OUT17/13050

**Kembla Grange Resource Recovery Facility Upgrade (SSD 5300 MOD 1)
Comment on the Environmental Assessment (EA)**

Mitchell Isaacs
Director, Planning Policy & Assessment Advice
28 March 2017

DRAWING TITLE
 Landscape Plan

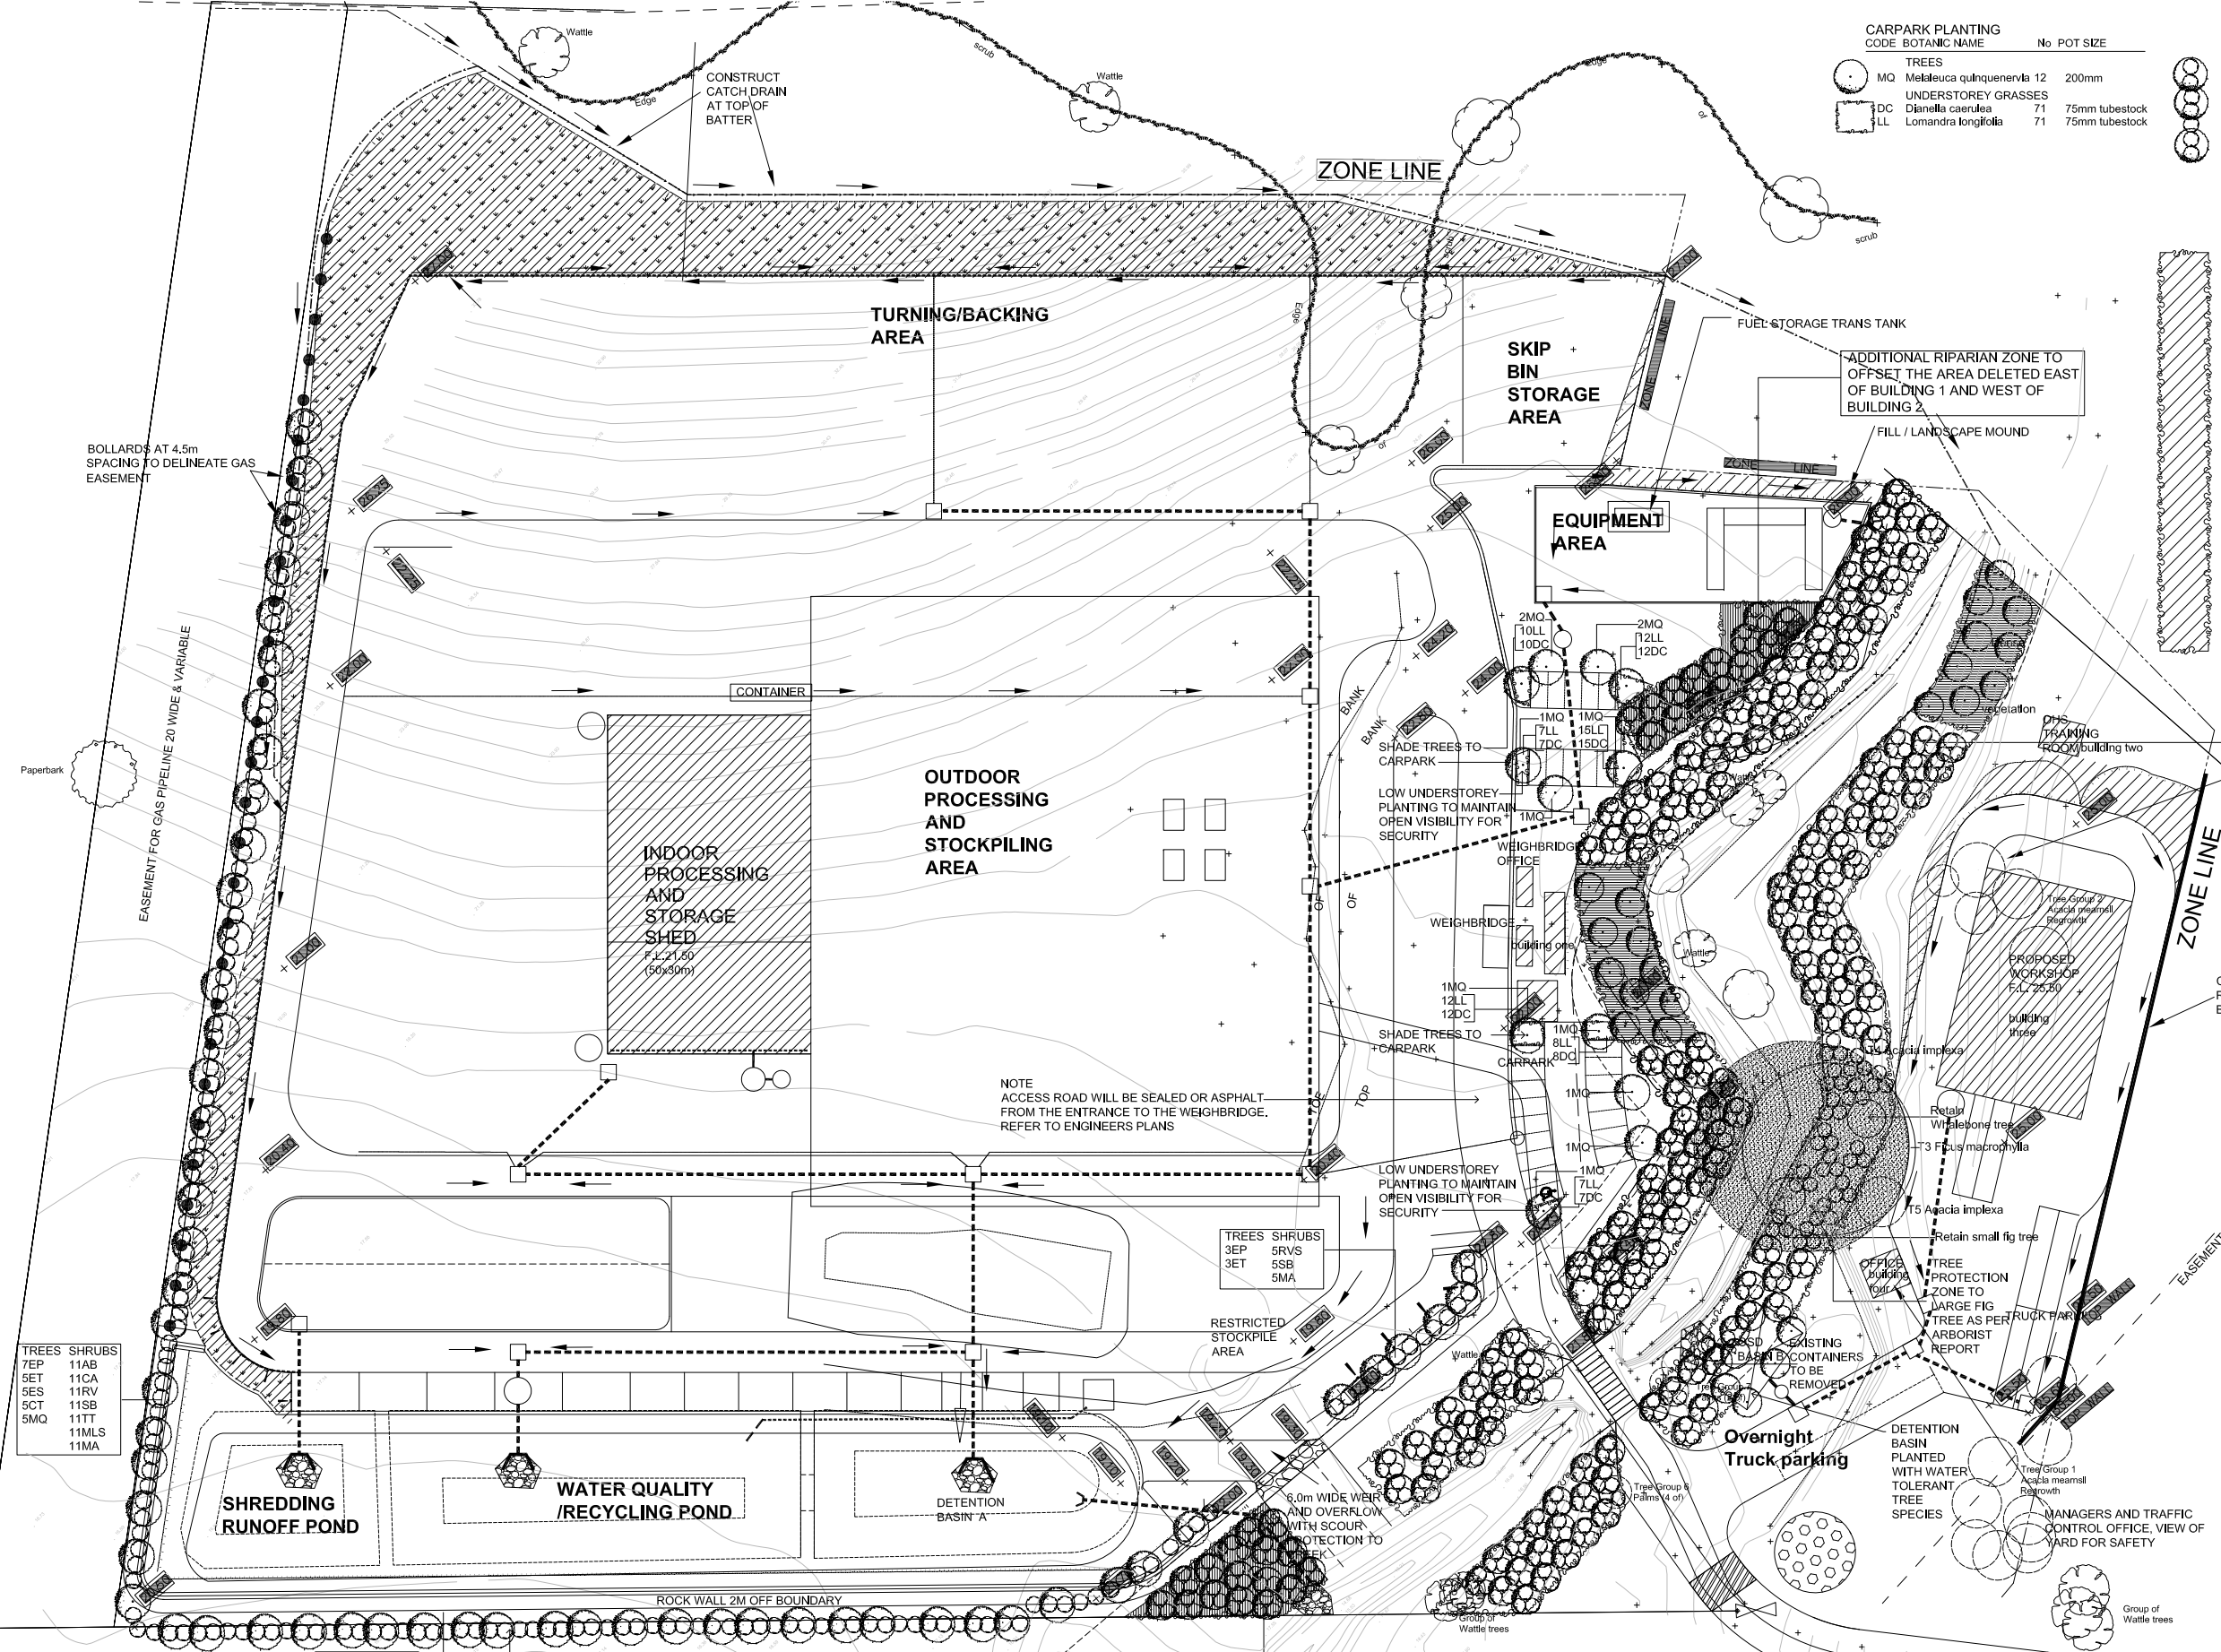
- The proponent should advise if any works associated with the proposed modification may disturb riparian land along the unnamed tributary of Gibsons Creek. If so, in order to assist DPI in assessing potential impacts and advising solutions and mitigation proposals, the proponent should provide details including:

- o a scaled plan which shows the location of:
 - the un-named tributary of Gibsons Creek
 - top of bank
 - the riparian corridor width along either side of the creek

- the footprint of the proposed modification works within the riparian corridor
 - the total area of riparian land that will be temporarily and/or permanently affected

- the site boundary
- The Landscape Management Plan, which is required to be updated following a modification to the consent, should include details on the rehabilitation of riparian vegetation.
